MEMORANDUM

To: FILE
From: Jean Fraser
Subject: Application ID: 2014-016
Date: 5/22/2014

Comments Submitted by: Marge Schmuckal/Zoning on 5/21/2014

PROJECT PH WARREN AVENUE, LLC
SHEET TITLE SITE LAYOUT AND UTILITY PLAN

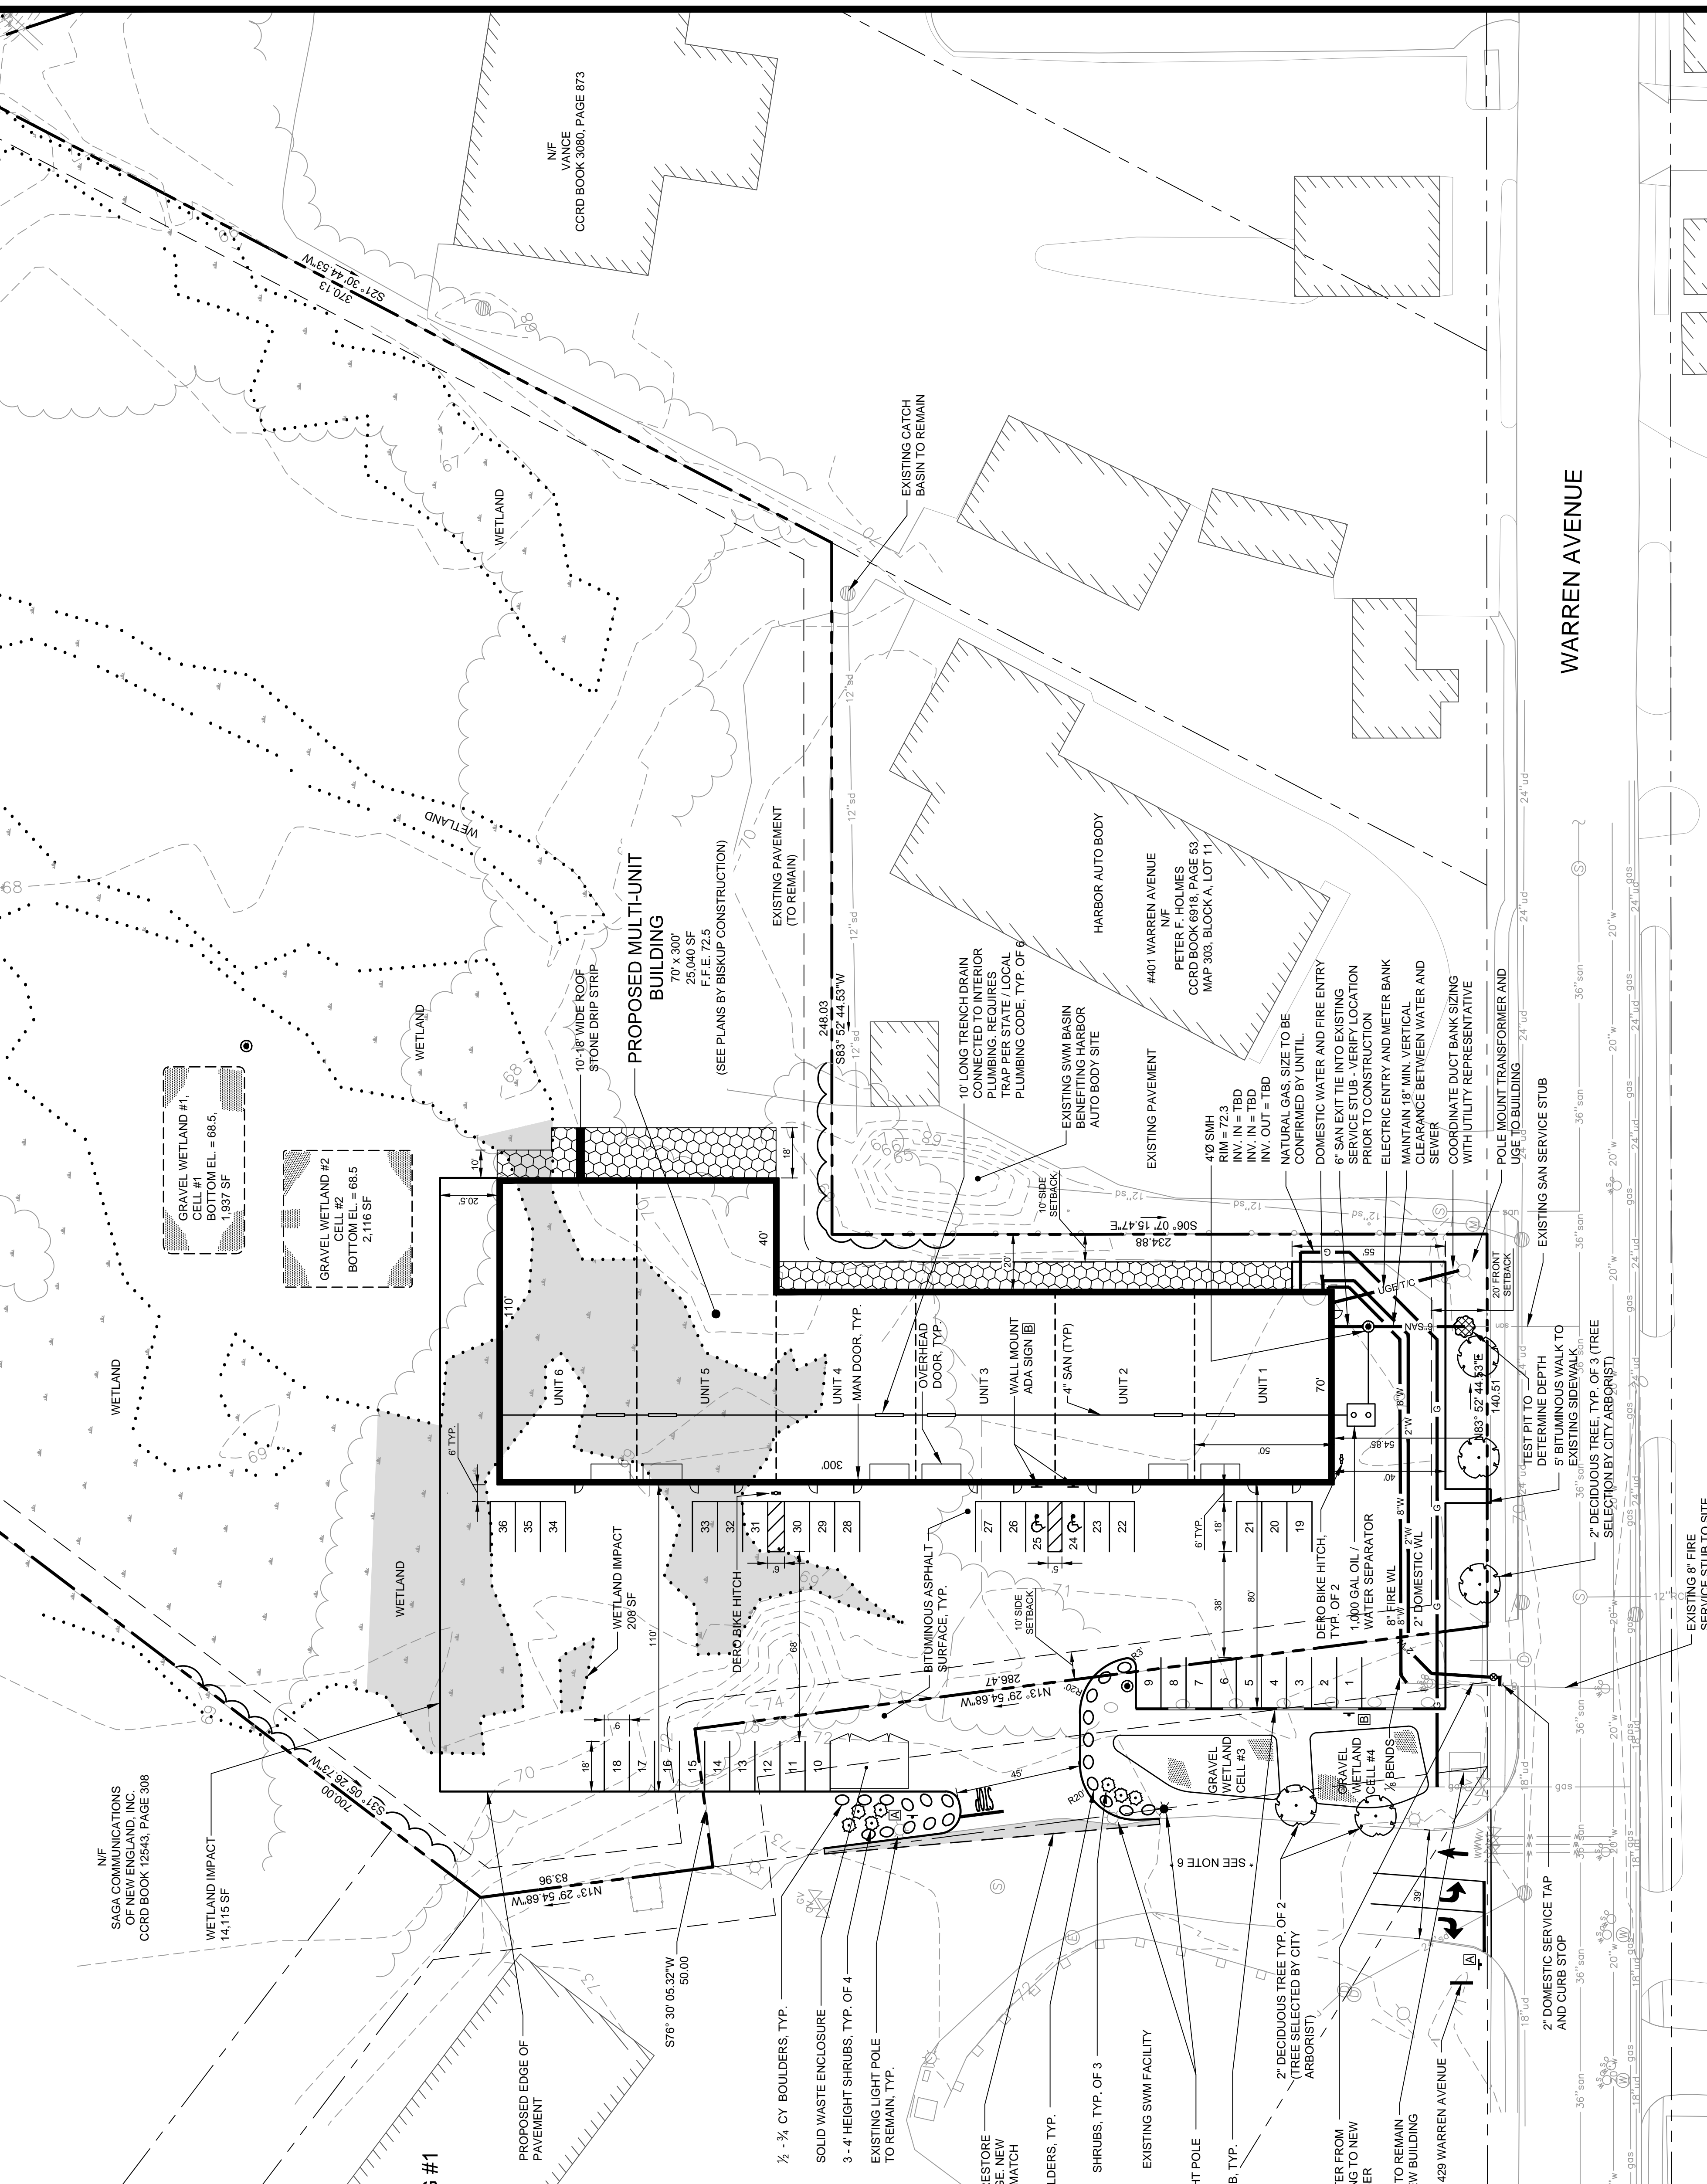
The uses affect the parking requirements. If all the uses are business, manufacturing & industrial uses, then 1 parking space per 1000 sf of floor area is required or 29 parking spaces. 41 parking spaces are shown. I do like that more than the minimum spaces are shown in case a different use is requested later. It gives a good buffer. I also noticed that 14 of the parking spaces are on an adjoining property. Hopefully there are easements that run with the property for those spaces.
